WELWYN HATFIELD COUNCIL – DEVELOPMENT CONTROL
DELEGATED REPORT

APPLICATION No:	S6/2011/1116/FP
------------------------	------------------------

DRWG: FRONT AND REAR
 ELEVATIONS PROPOSED

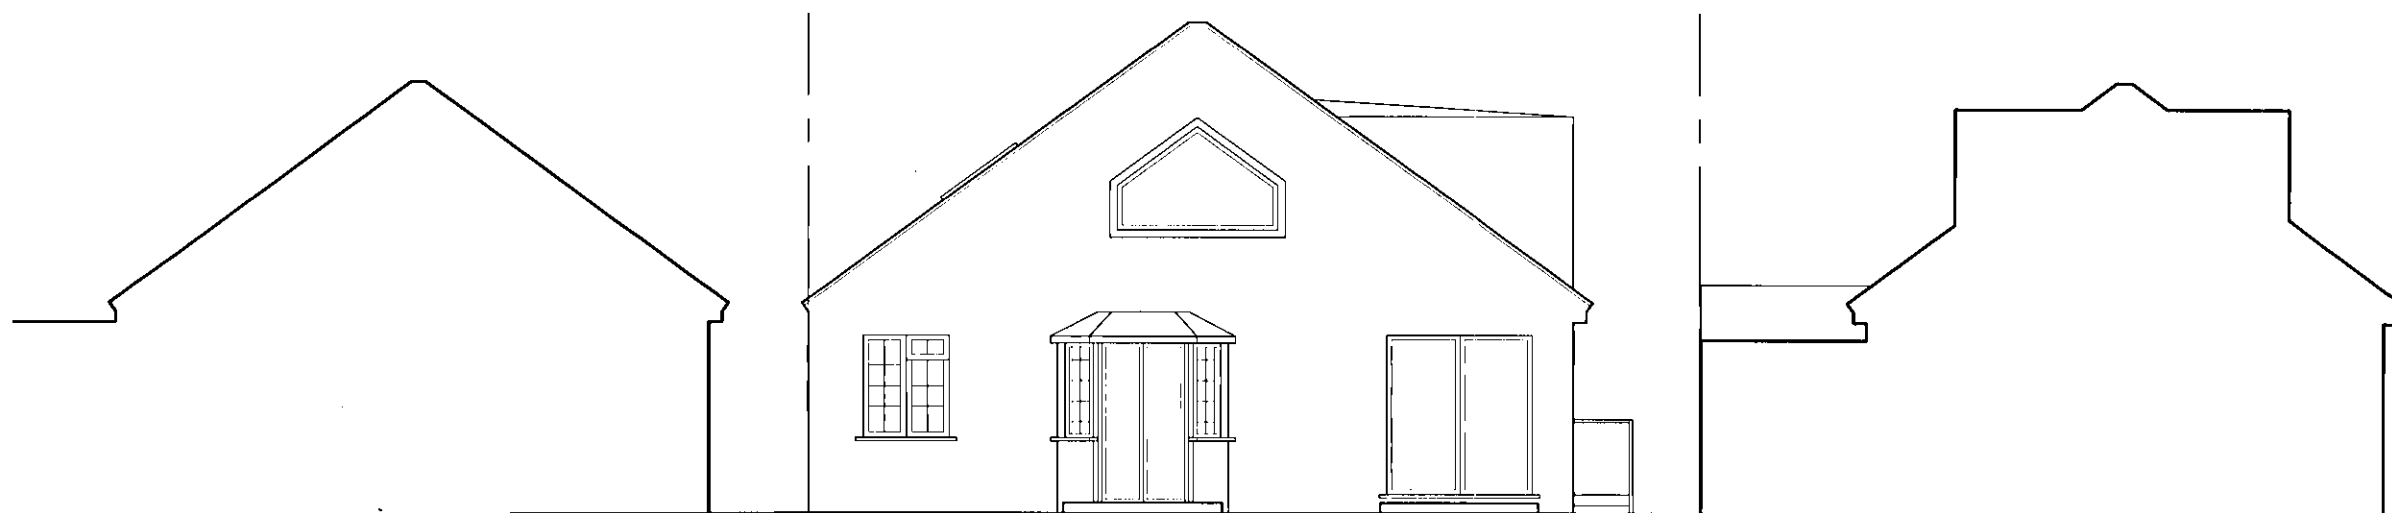
For this application, the proposal would result in the ridge height of the dwelling being increased by around 0.9m. It would also result in the addition of a half hipped gable on the front elevation and the roof towards No.40 Theobalds Road being extended.

These changes would alter significantly the appearance of the existing bungalow, particularly when viewed from the front. Policy D2 requires new development to respect and relate to the character and context of the area. The Supplementary Design Guidance also requires extensions to 'complement and reflect the design and character of the dwelling and be subordinate in scale'.

The current proposal would result in an unbalanced appearance to the front elevation, which would also reduce the visual gap with No.40. This would conflict with the prevailing established character of streetscene of dwellings which have simple hipped roofs, all of the same height and separated by similar spaces.

Furthermore, the proposed extensions have not been designed to compliment and reflect the character of the existing building. The introduction of a gable to the front of the roof would not reflect the character of the existing dwelling and so would appear as an alien feature.

In summary, the extensions and roof enlargement would not be subordinate in scale with the original bungalow due to the additional bulk and height. The use of a gabled roof would result in an incongruous feature in the street scene detrimental to the established character of the immediate area.

- 1. The proposal would, by reason of its incongruous design, height and scale, significantly harm the appearance of the existing dwelling and the established character of the streetscene of Theobalds Road, due to proposed increase in the height of the roof ridge, along with a side roof extension, both of which would result in an unbalanced appearance at odds with the character of the existing dwelling and neighbouring bungalows. In addition, the addition of a gable to the front elevation further adds to this harm by creating an alien feature. The proposals are therefore contrary to Policies D1 and D2 of the Welwyn Hatfield District Plan 2005 and Supplementary Design Guidance (Statement of Council Policy).

DRWG: LOFT FLOOR PLAN
PROPOSED

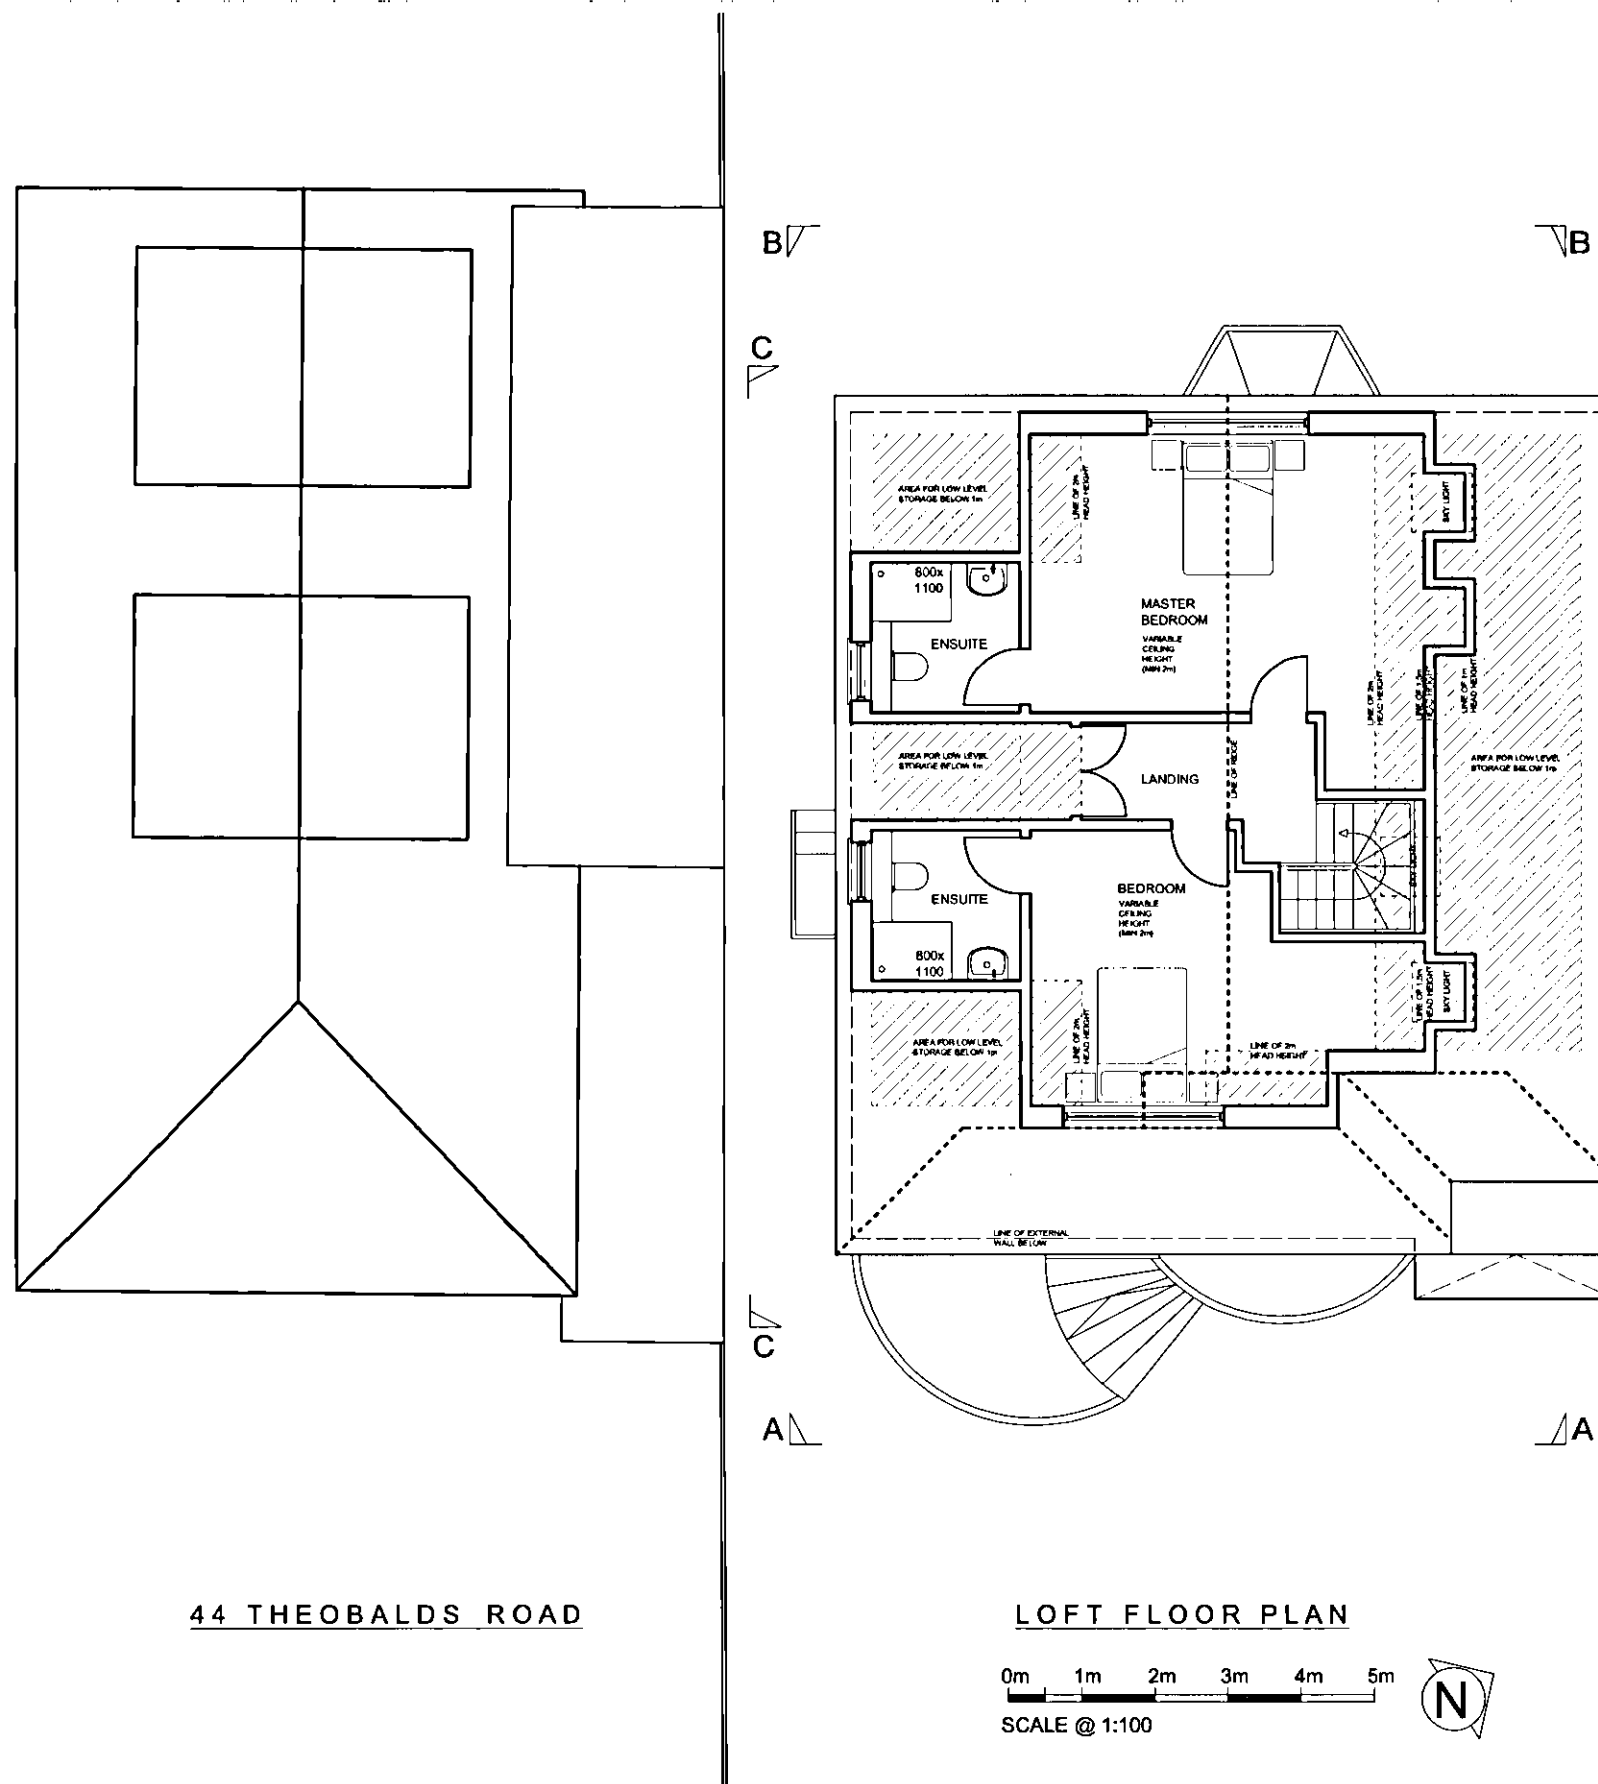
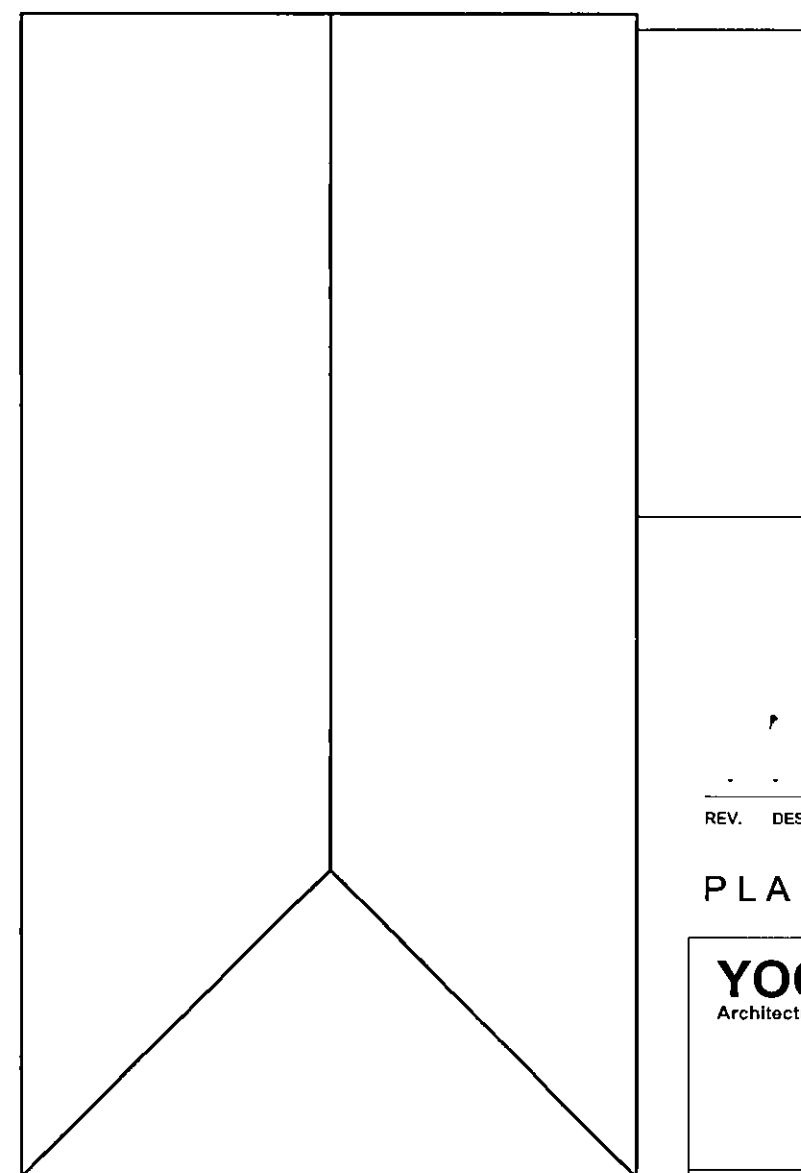
New first floor accommodation is proposed to create a master bedroom and second bedroom, both with en-suites.

Two side dormers with flat roofs are proposed on one roof slope to serve the new en-suites and three rooflights are proposed on the opposite side roof slope to serve as secondary windows to new bedrooms.

The impact on No.44 would result mainly from the new dormers, however, the size and location of these would not result in any significant loss of sunlight/daylight to this neighbour. As both of these dormers are for en-suites a planning condition for obscure glazing and non-opening below eye level would be reasonable.

DRWNG: SIDE ELEVATIONS
 PROPOSED

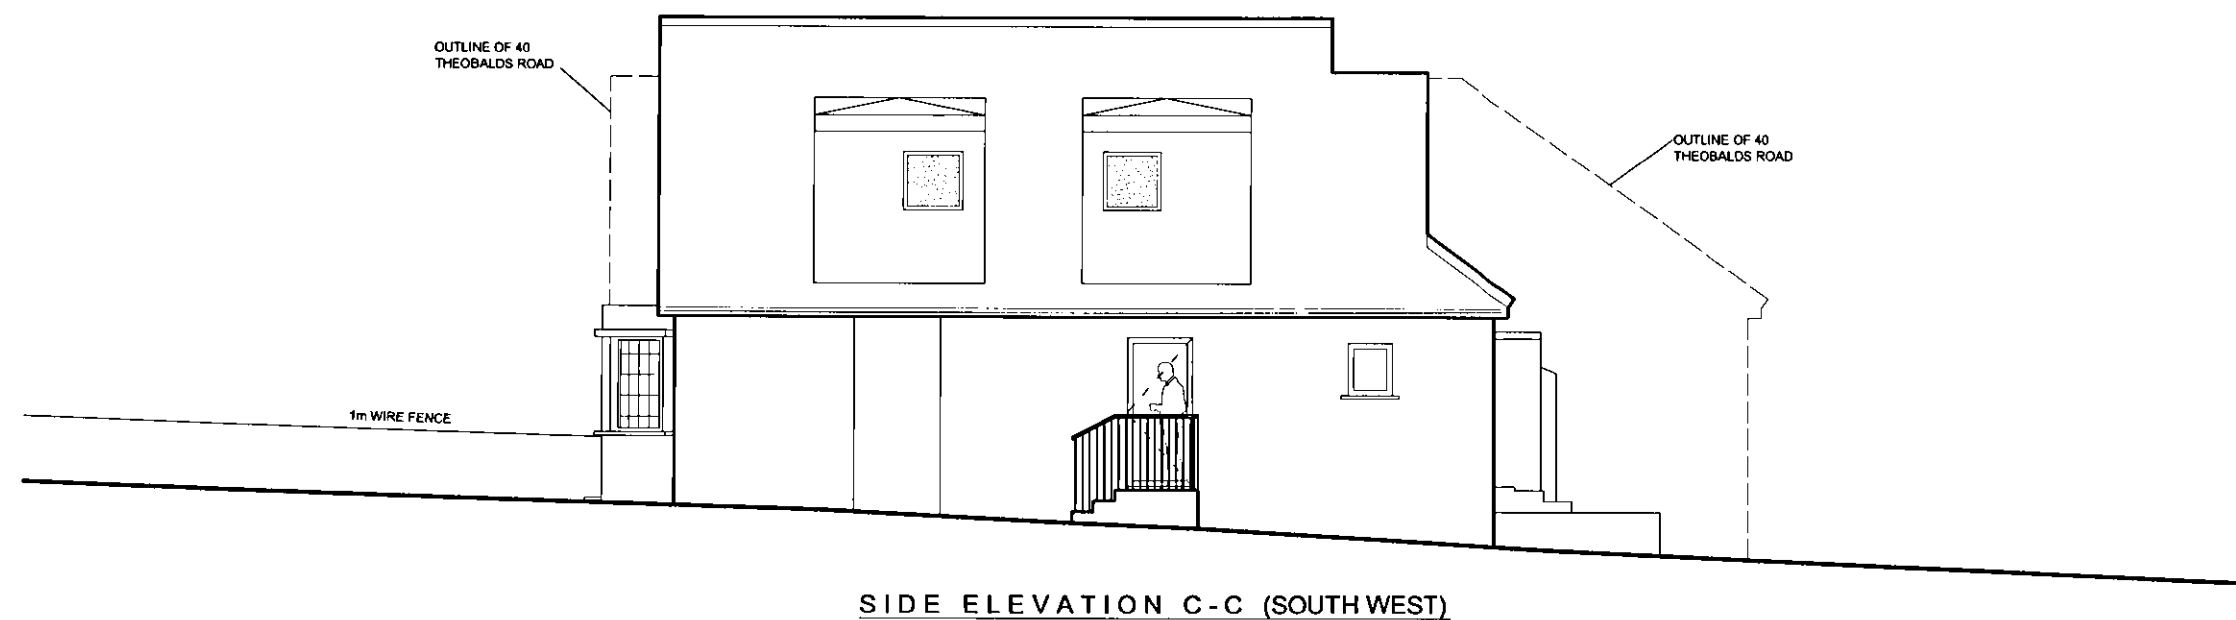
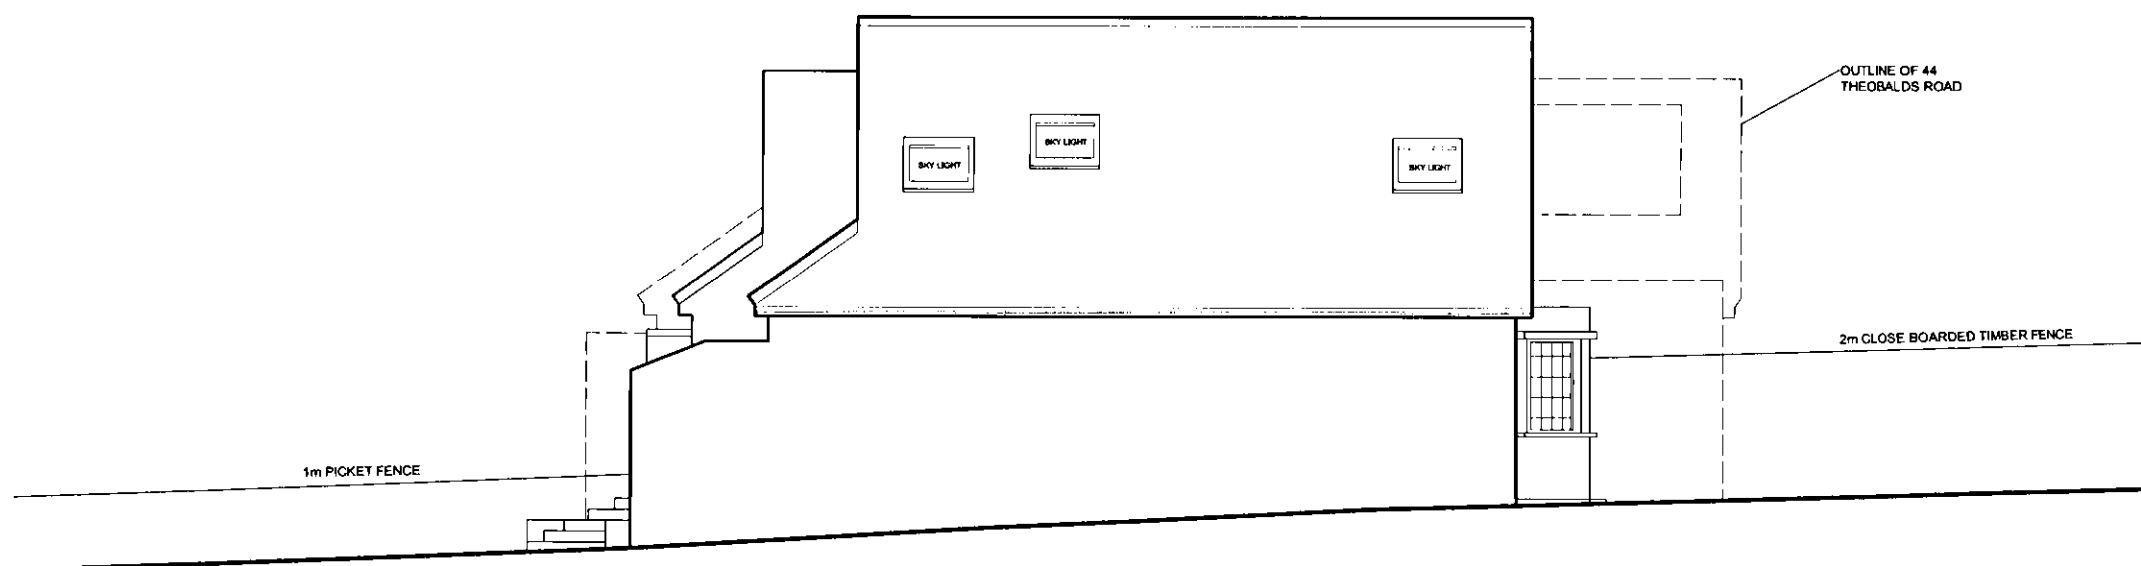
The impact on No.40 has the potential of being greater, as the roof would extend towards this neighbour and there would be an increase of around 0.3m to the height of the existing flank boundary wall. There is a number of existing flank wall windows to No.40 which face towards the application site, and which will be impacted by the proposed extensions. Some of these appear to be serving habitable rooms, although it remains unclear whether they are original to the property.

Taking this into account, the main issue is whether the loss of sunlight/daylight would to No.40 be so significant to warrant withholding planning permission on this issue. Overall, and on balance, whilst it is accepted that some loss of sunlight/daylight would result, the small increase in height of the flank wall, and the sloping roof behind this, would not significantly impact on the residential amenity of No.40.

The proposal therefore complies with Policy D1 of the Welwyn Hatfield District Plan 2005 and Supplementary Design Guidance, February 2005 subject to planning conditions for the windows to the dormers being obscure glazed and non-opening below 1.7m
